**WELWYN HATFIELD BOROUGH COUNCIL  
EXECUTIVE DIRECTOR - PLANNING, PUBLIC PROTECTION AND GOVERNANCE**

**DELEGATED APPLICATION**

**Application No:** 6/2018/3255/FULL  
**Location:** Plot 5610, Gypsy Moth Avenue, Hatfield Business Park, Hatfield, AL10 9BS  
**Proposal:** Erection of a pre-delivery inspection facility (Use Class B2), together with car storage area (Use Class B8), staff car parking, cycle parking, boundary treatment, landscaping, lighting and access  
**Officer:** Mr David Elmore  
**Recommendation:** Granted

6434 - 005  
 PLANNING

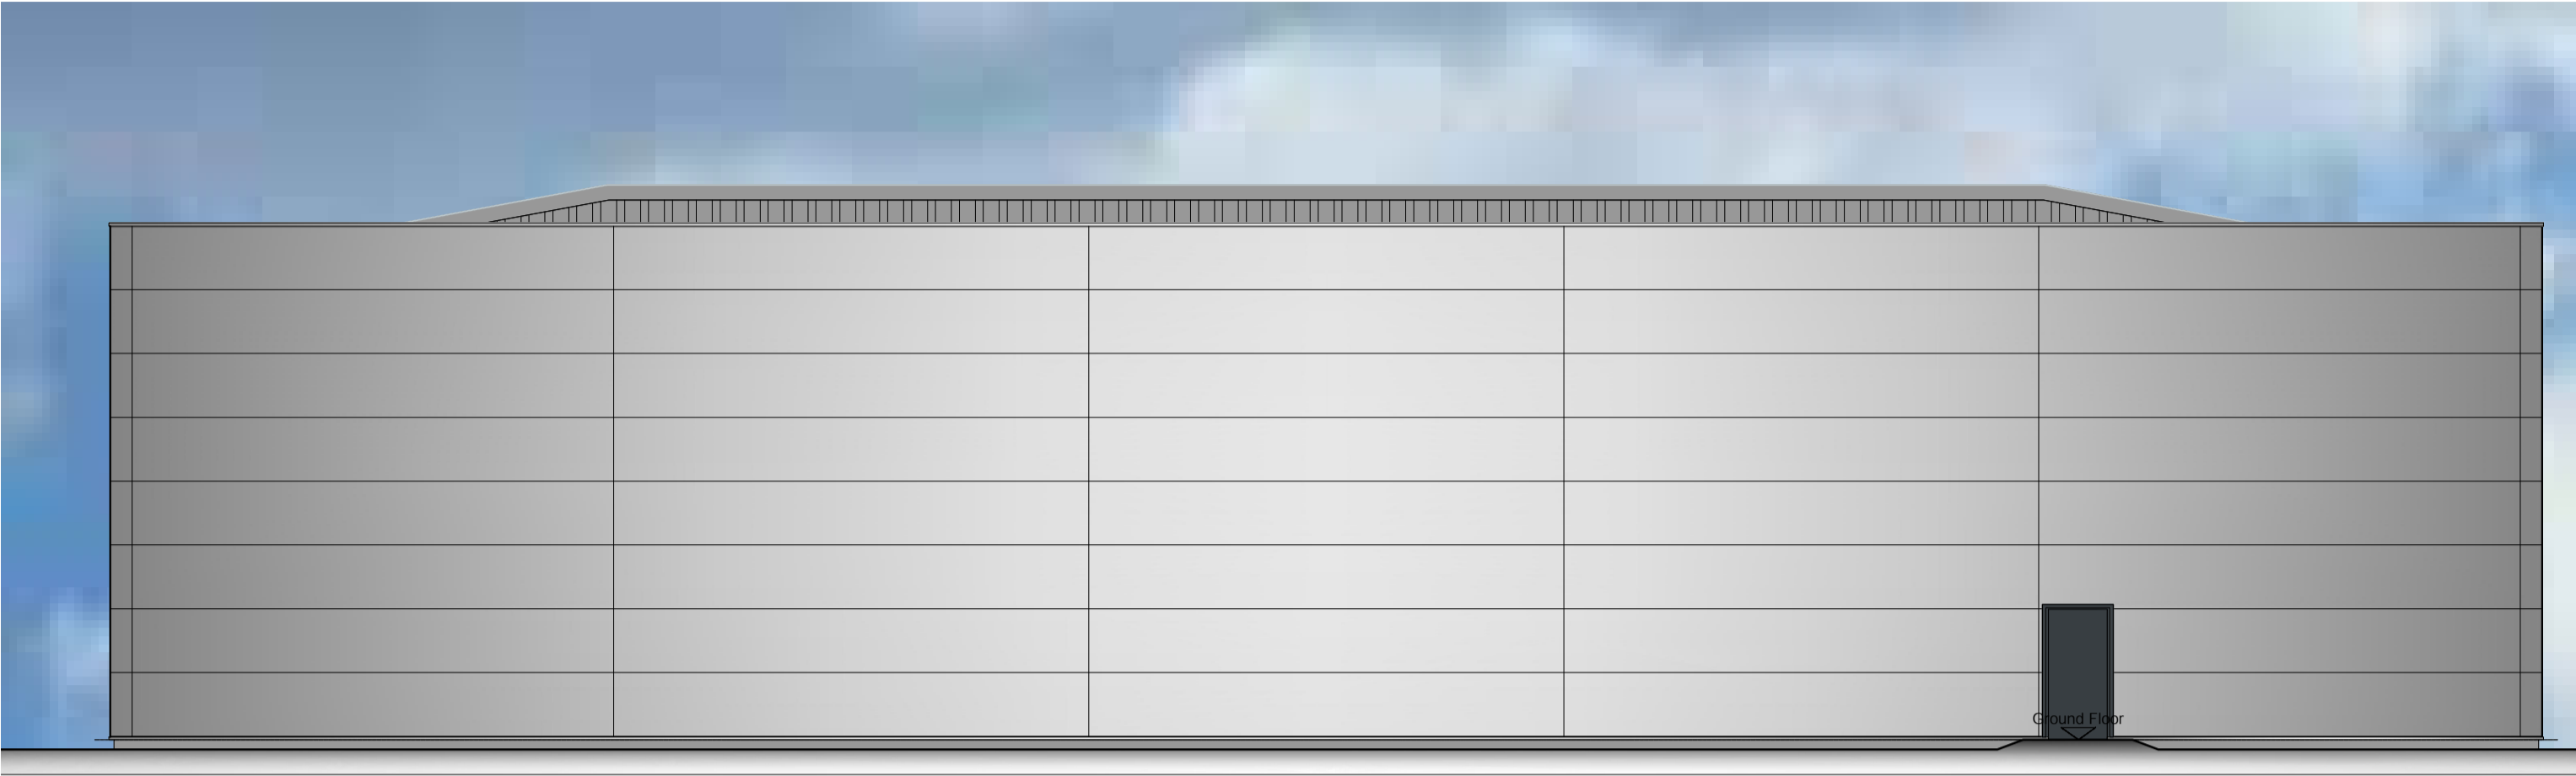
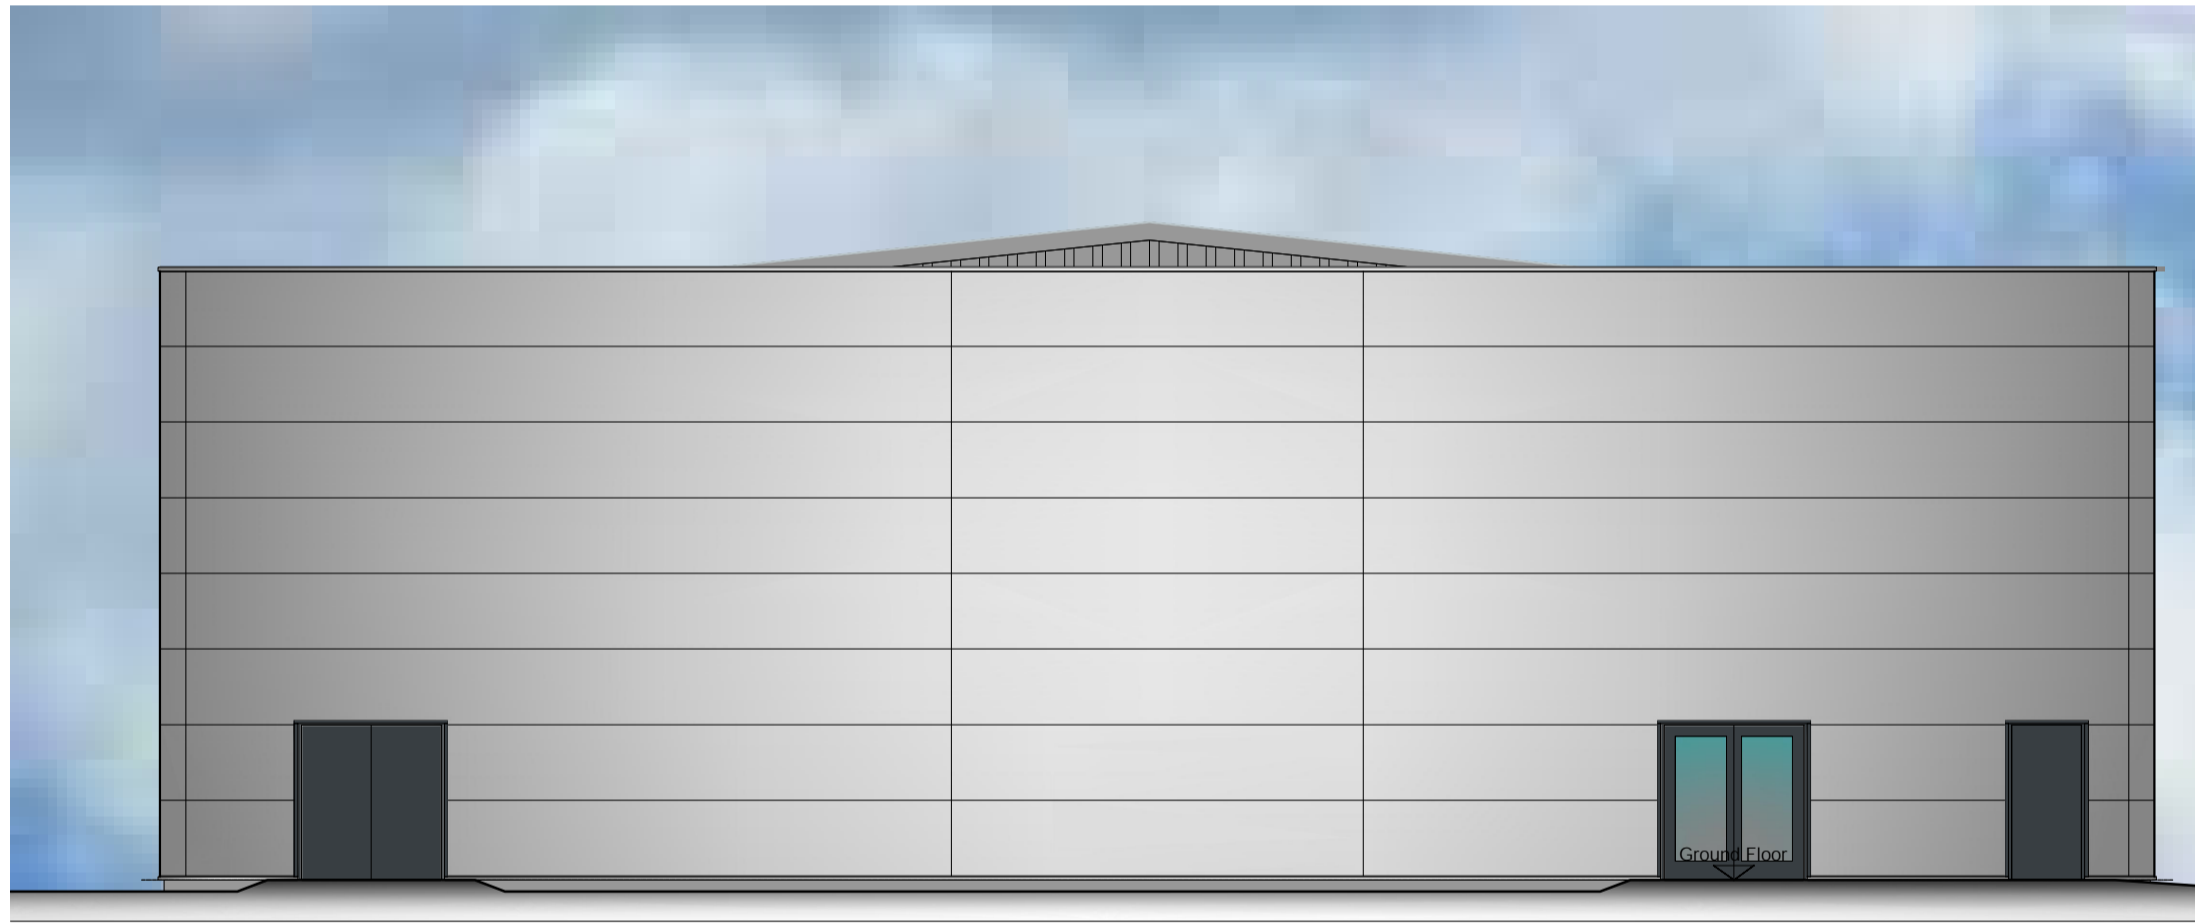
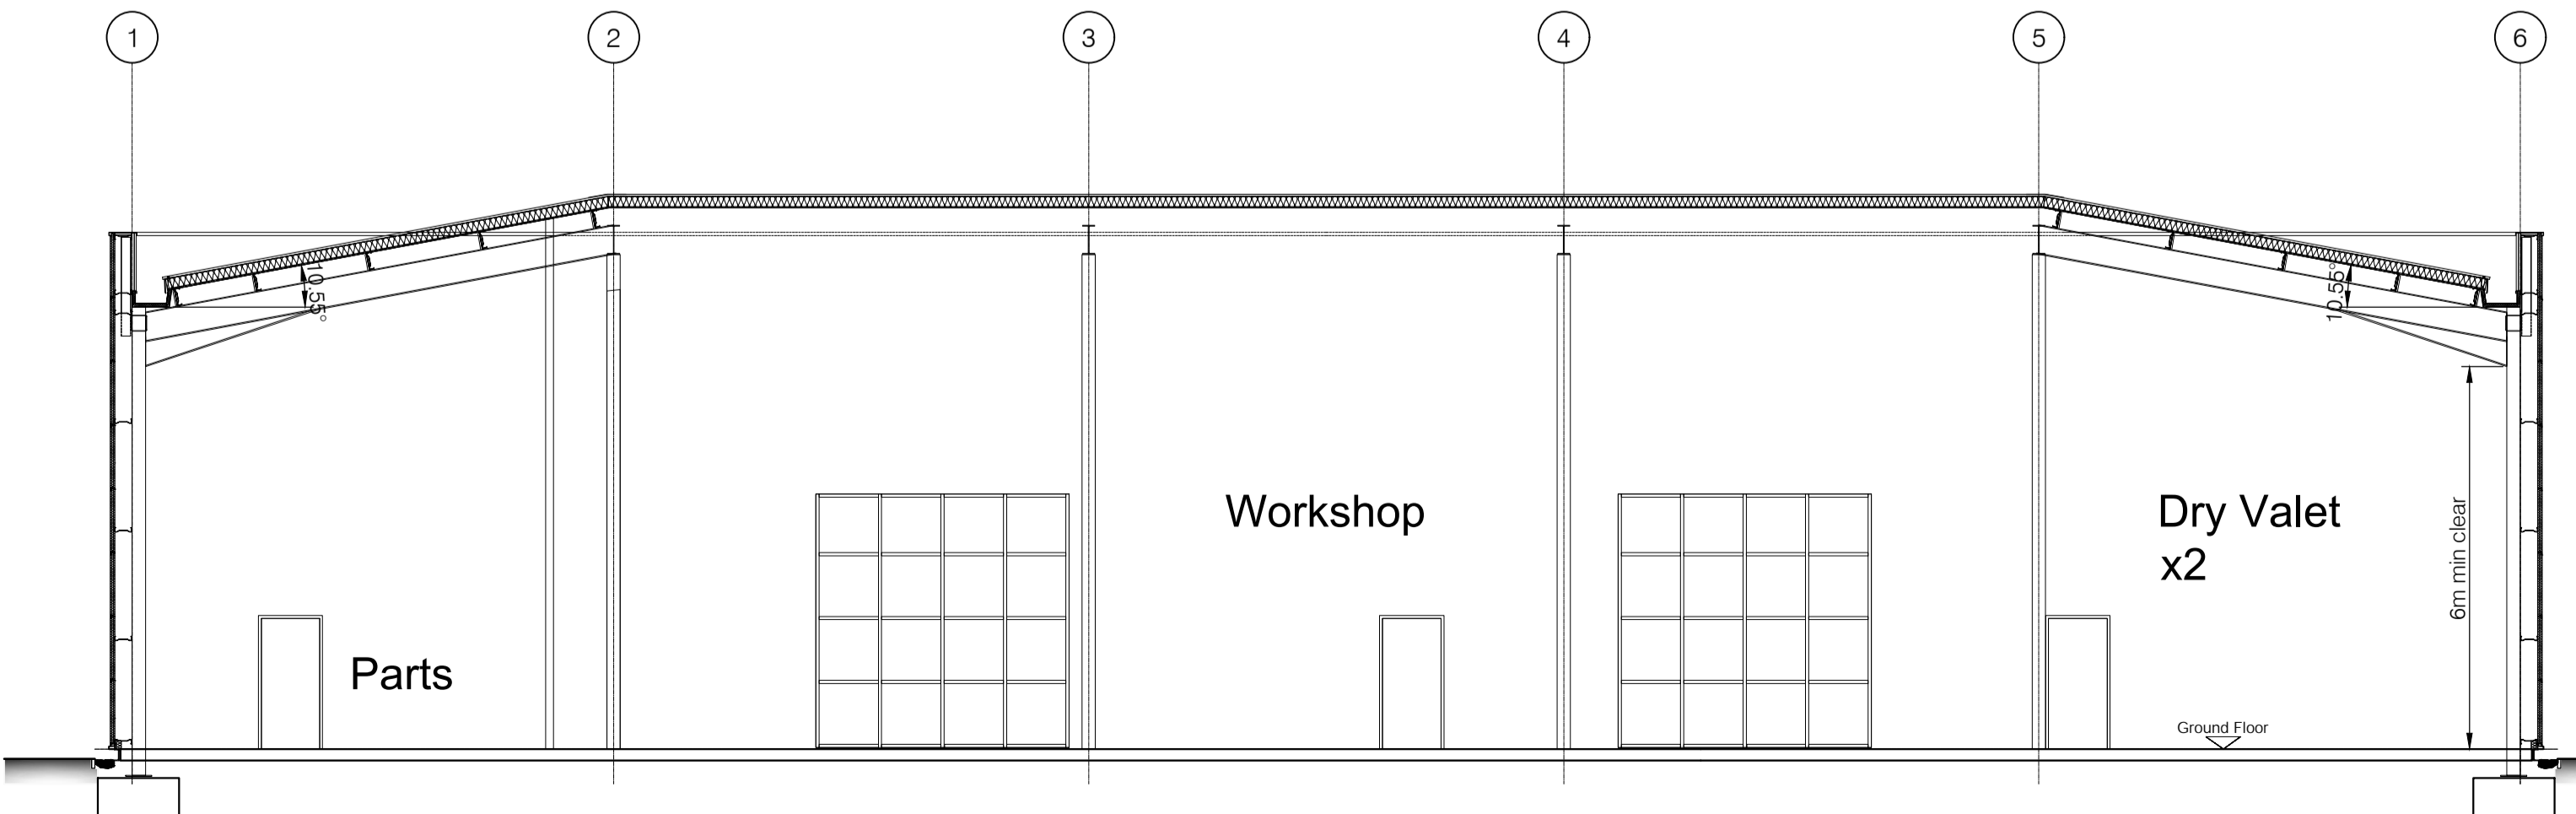
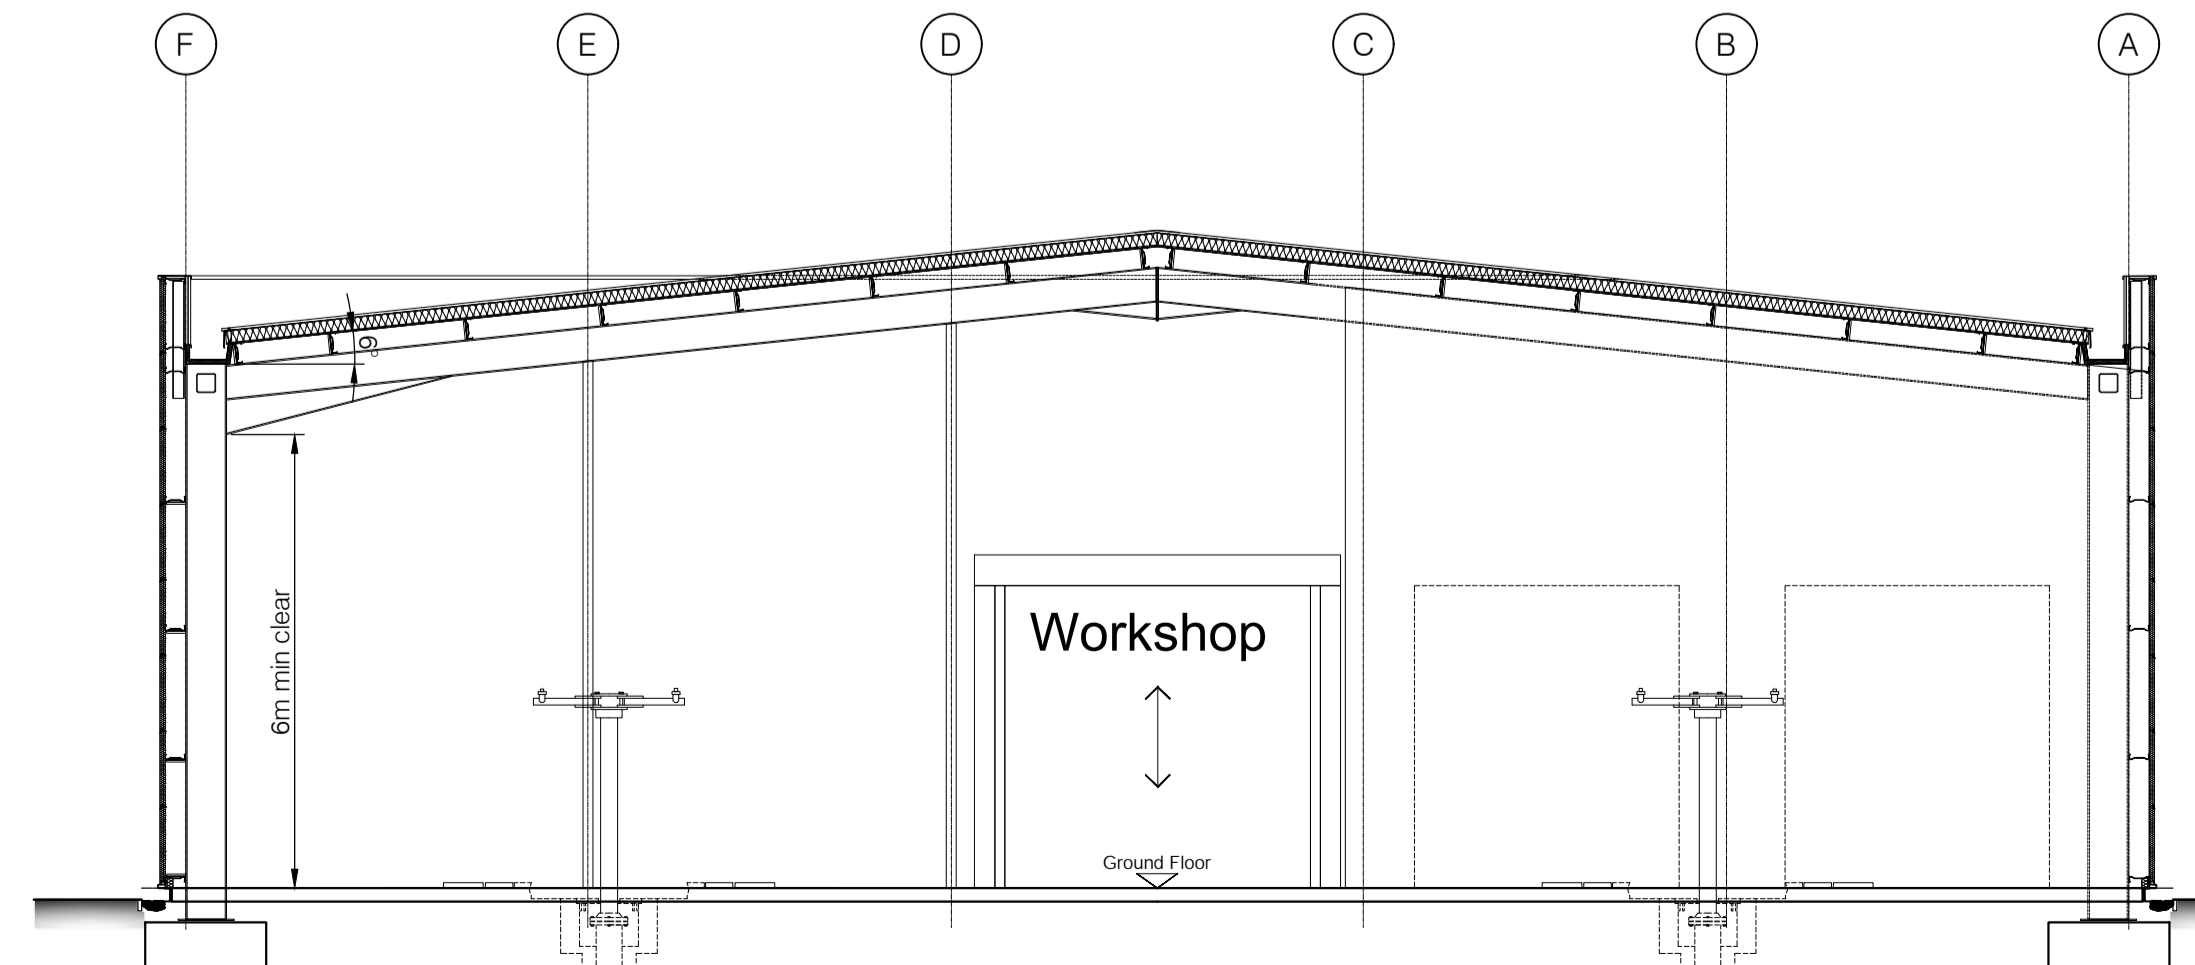
The proposed pre-delivery inspection building would be sited in a broadly central position on the plot with a simple form. The footprint of the building measures approximately 38.5m long x 26.5m wide and 6m to the underside of internal haunch with a further 2.7m approximately to the ridge. The footprint and scale of the building is appropriate in the context of the surrounding built form, in

The building would be faced in horizontal cladding (coloured silver) below a profiled steel roof (coloured grey). Window frames and doors would be a powder coated aluminium (coloured dark grey). Whilst precise manufacturer details of the materials have not been provided, the principle of these materials are acceptable. Precise details of the palette of materials can be secured through a planning condition.

4. No development of the building hereby granted above ground level shall take place until samples of the materials to be used in the construction of the external surfaces of this building have been submitted to and approved in writing by the Local Planning Authority. The development must be implemented using the approved materials and subsequently, the approved materials must not be changed.
